Recommendation Report for Planning Permission for Works or Extension to a Dwelling

REF NO: LU/50/22/HH

LOCATION: 92 Westlands
Rustington
BN16 3NW

PROPOSAL: Single storey side extension.

**Extension
Proposed Ground Floor Plan**

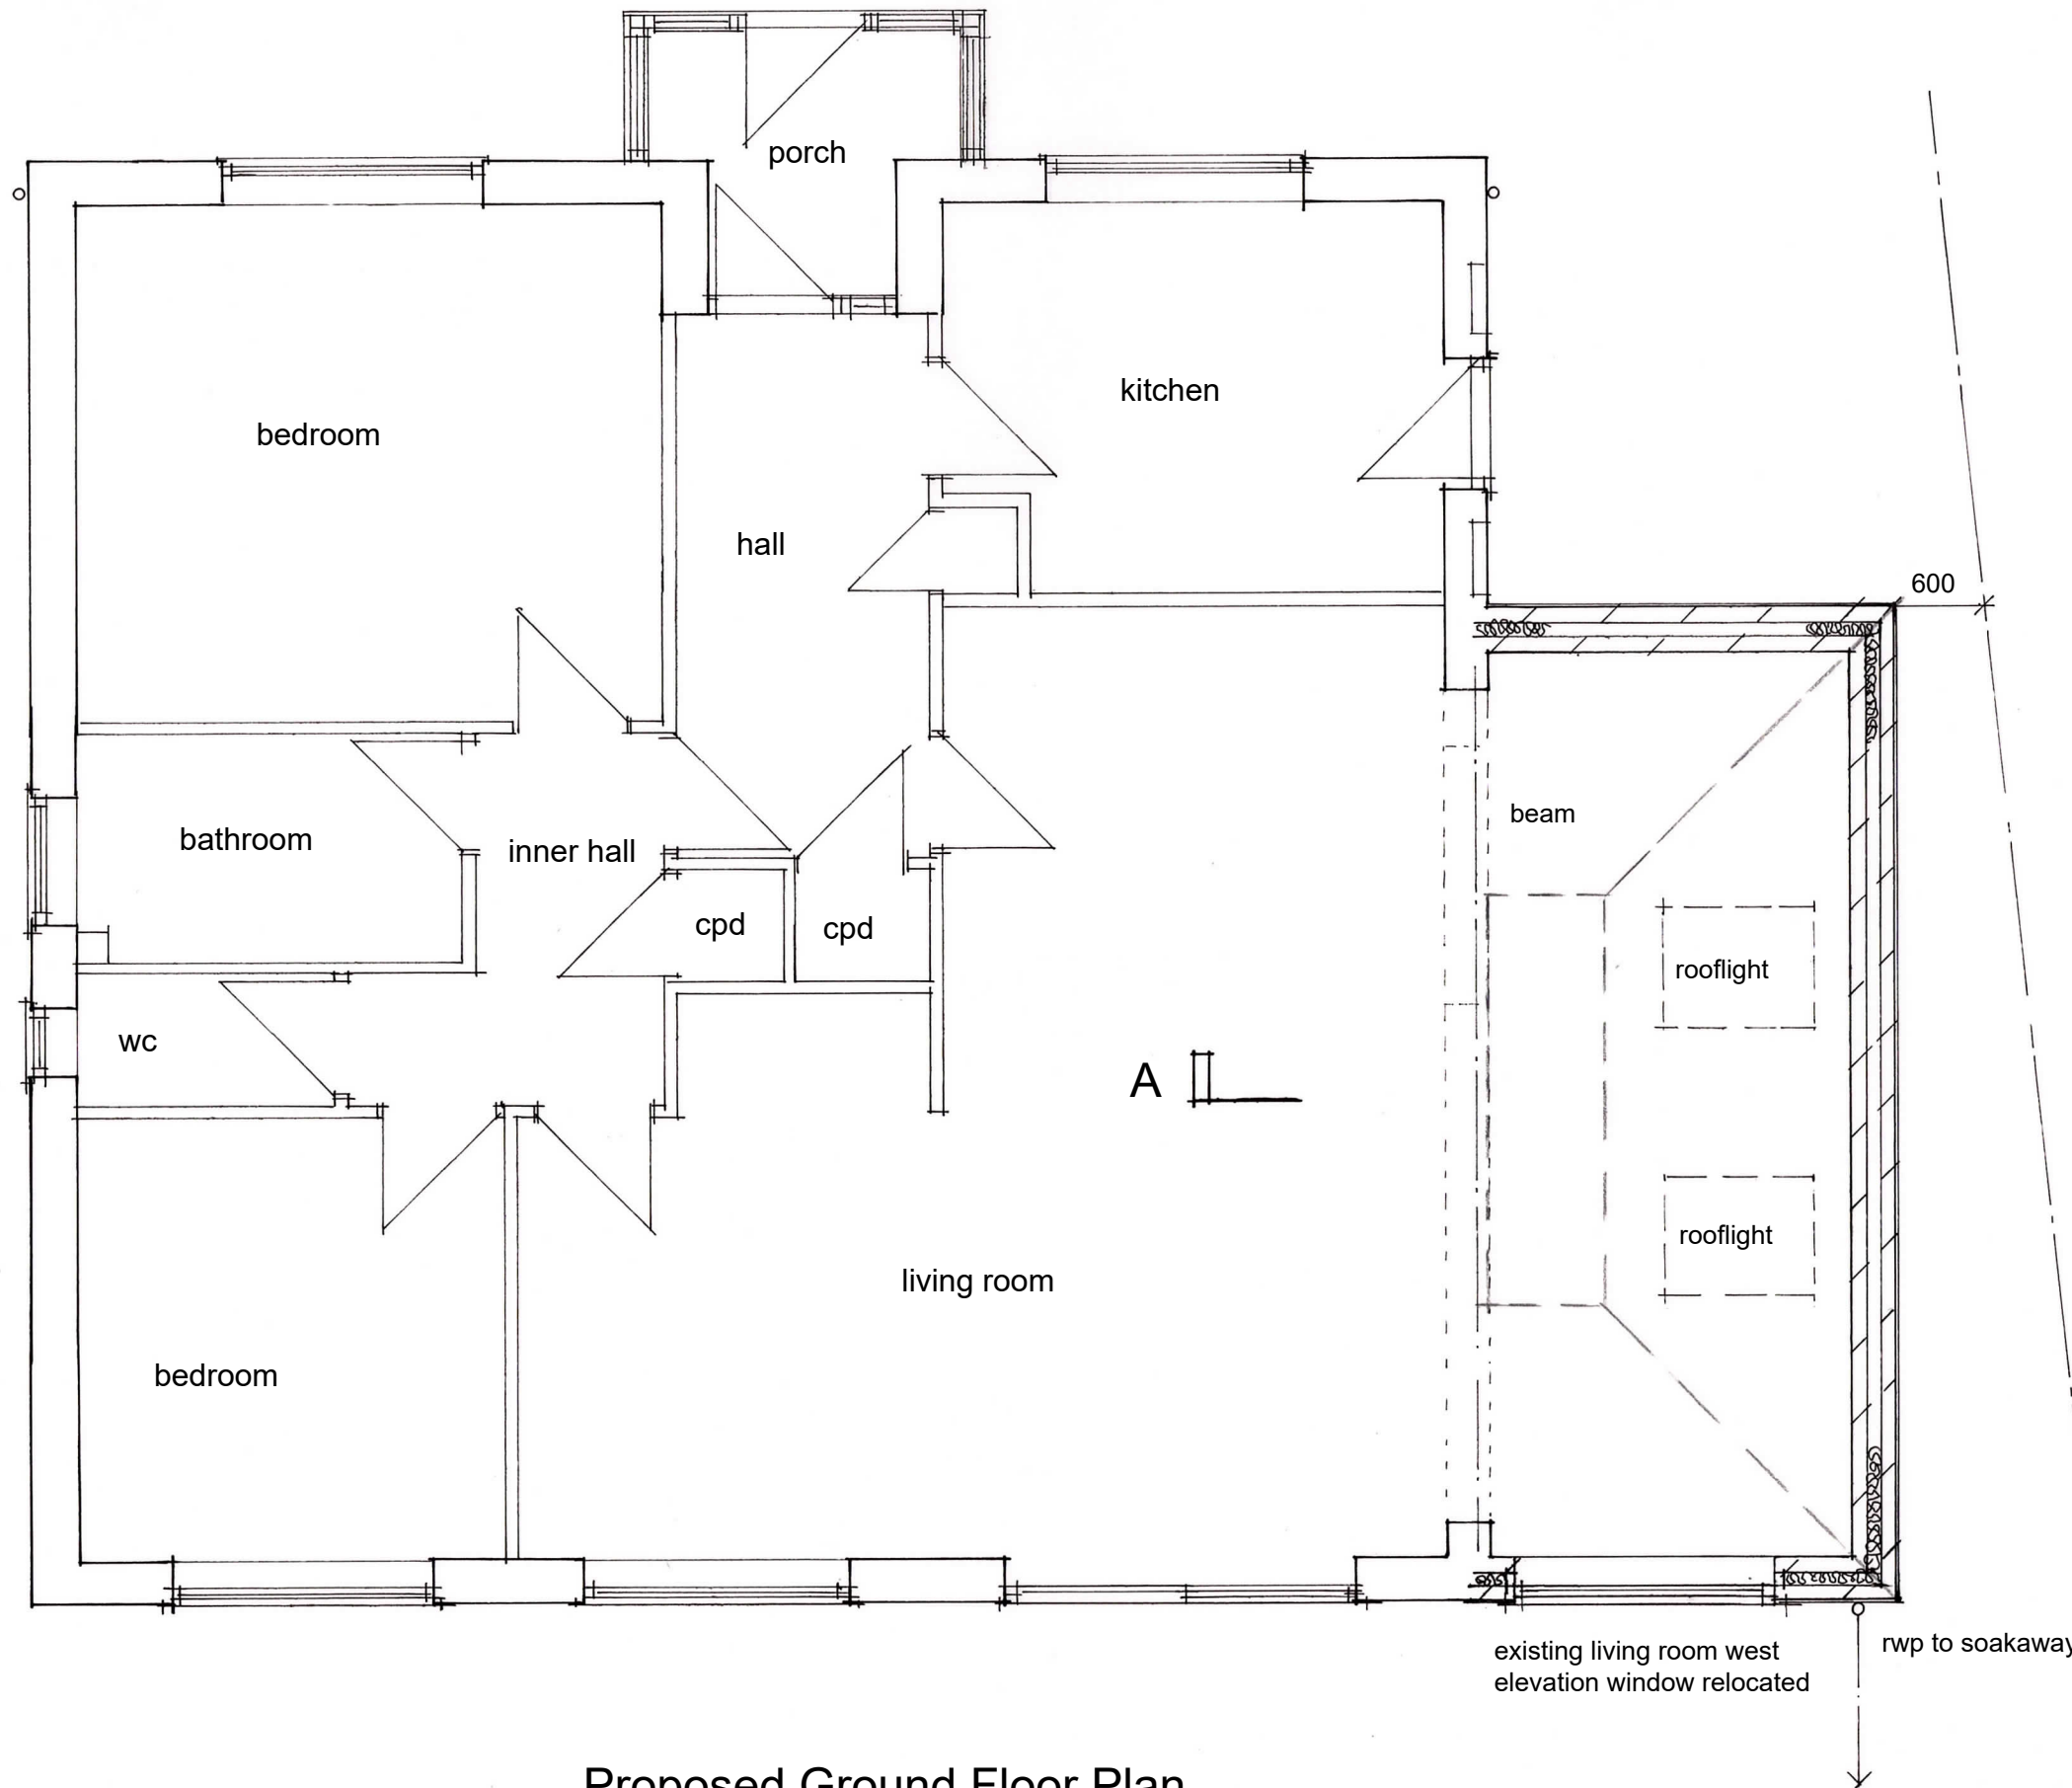
To the rear elevation of the proposal, there is to be 1 No. new rear window. This window is to look out to the rear garden and is on ground floor level. As such, this proposal gives no adverse impacts by way of overlooking on any neighbouring dwellings.

**Extension
Proposed Elevations & Roof Plan**

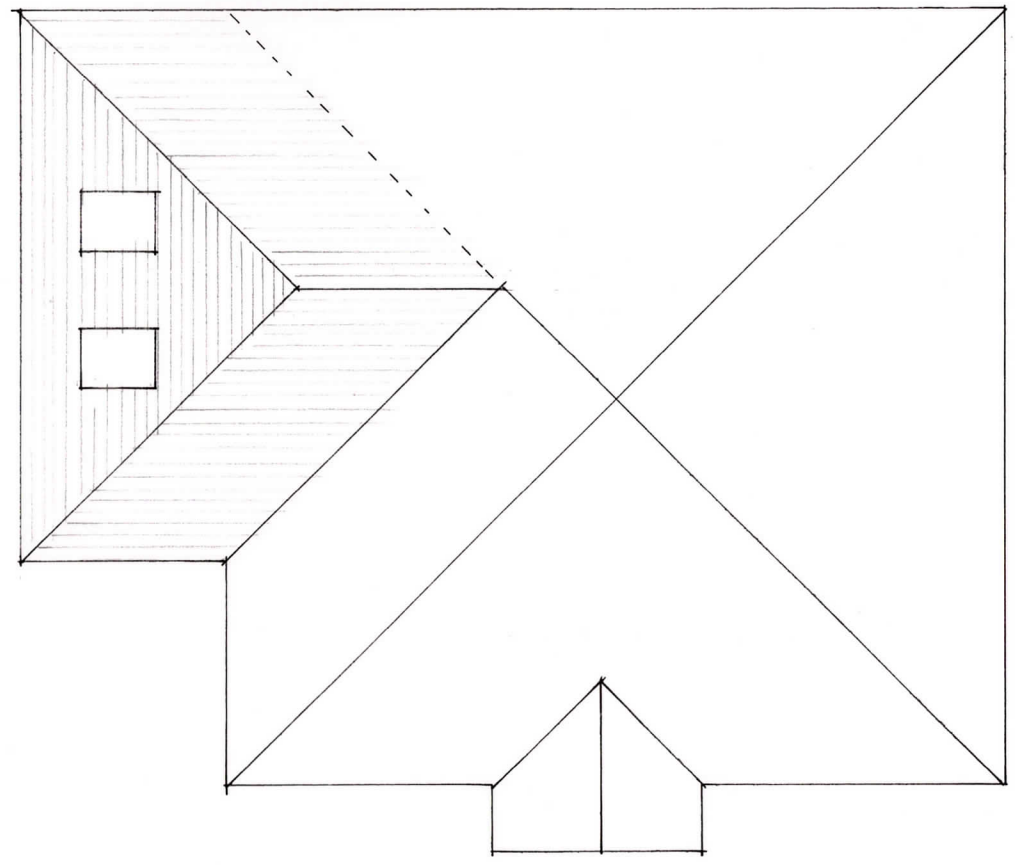
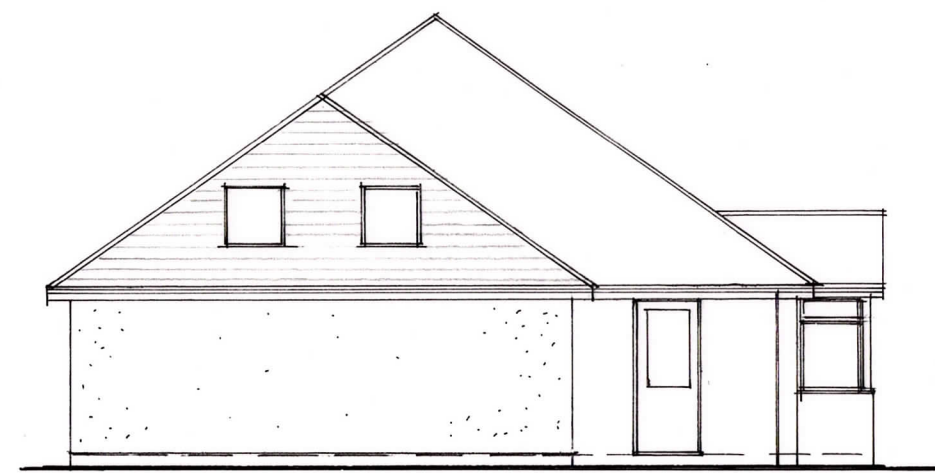
The proposal is of a scale, form and siting that makes it a visually subservient addition to the host dwelling. It is sympathetically designed with a matching roof pitch and design with eaves at equal height to that of the host dwelling. The ridge of the roof is set approx. 1m lower than that of the main dwelling and the extension is set back from the front elevation by approx. 3m making this extension subservient and resulting in a complimentary scale and siting.

The materials proposed are acceptable. They are to match the existing dwelling with the exception of the external walls. These are to be decorated render with a white coloration. This is an acceptable choice of materials as white render is a common feature within the locality. Although not matching to the walls of the existing dwelling, it is not a visually adverse contrast and will only have minimal views from the street, making it an acceptable visual alteration to the street scene.

Site & Block Plan

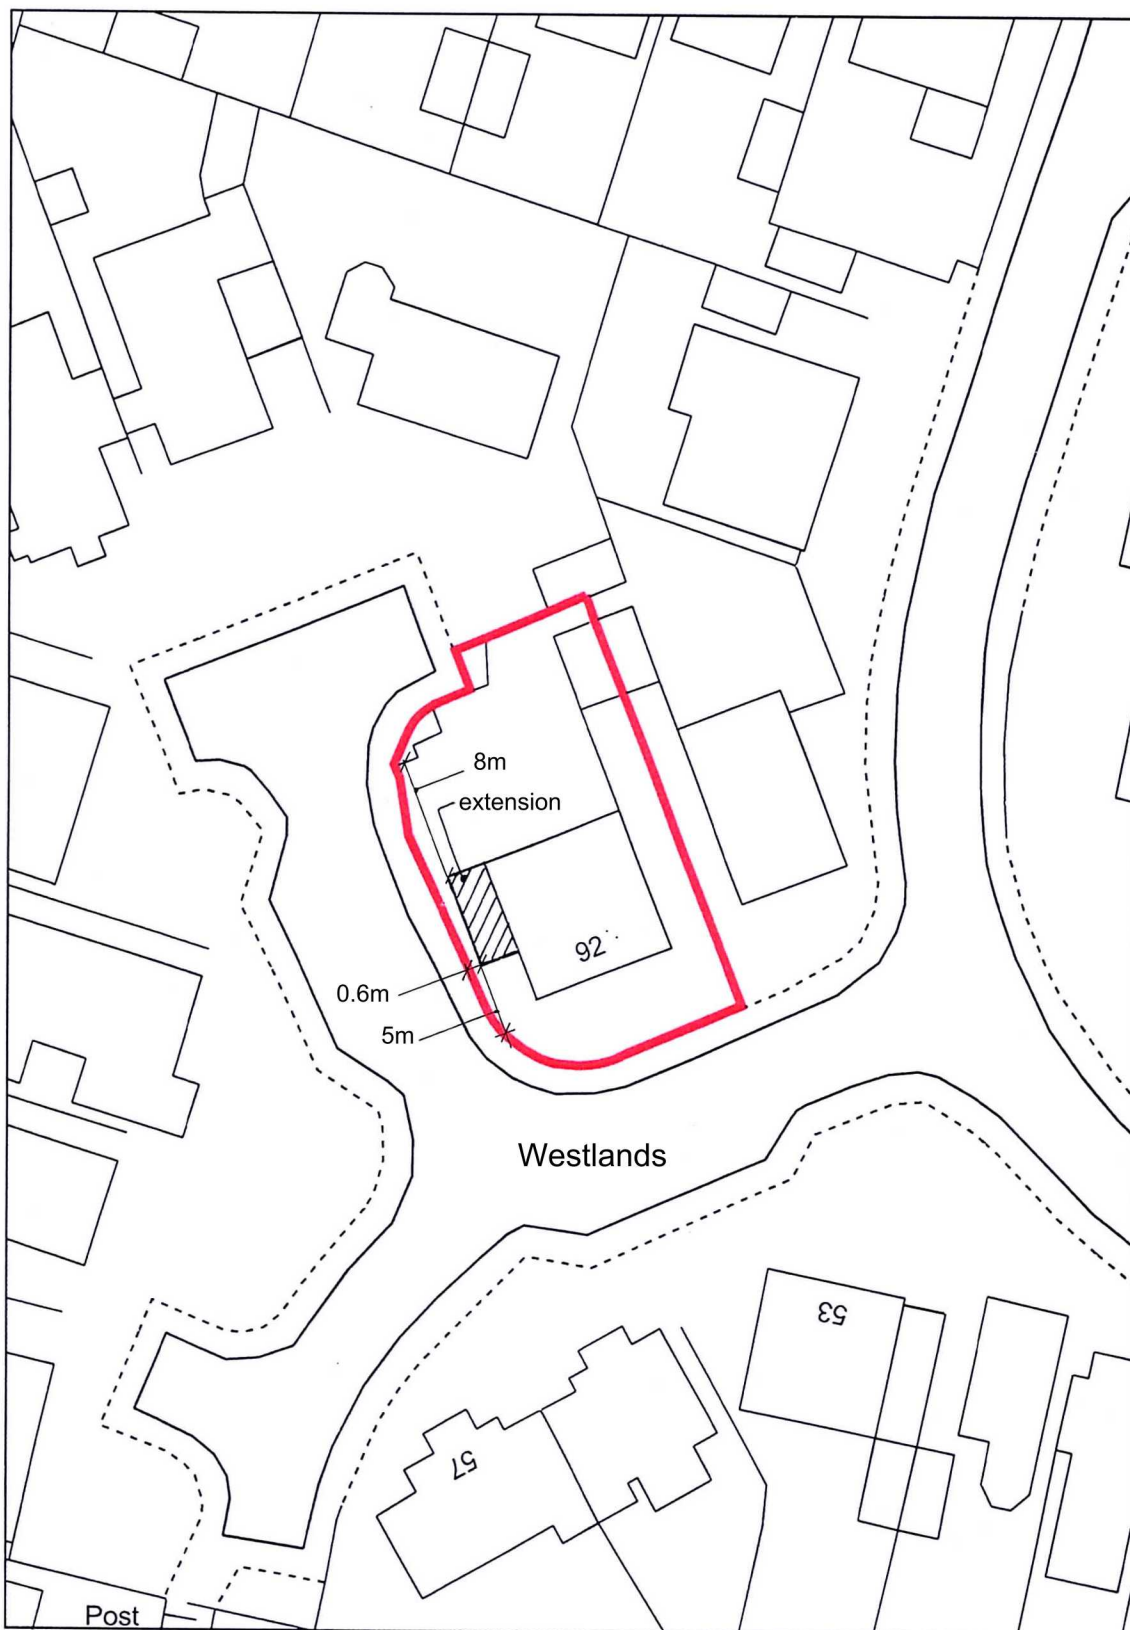
The proposal is 0.6m from the West (side) site boundary which is less than the recommended 1m spacing set out by Section M of the Arun Design Guide. However, this is a corner dwelling and the West (side) site boundary is met by the street. As such, this separation distance is acceptable.
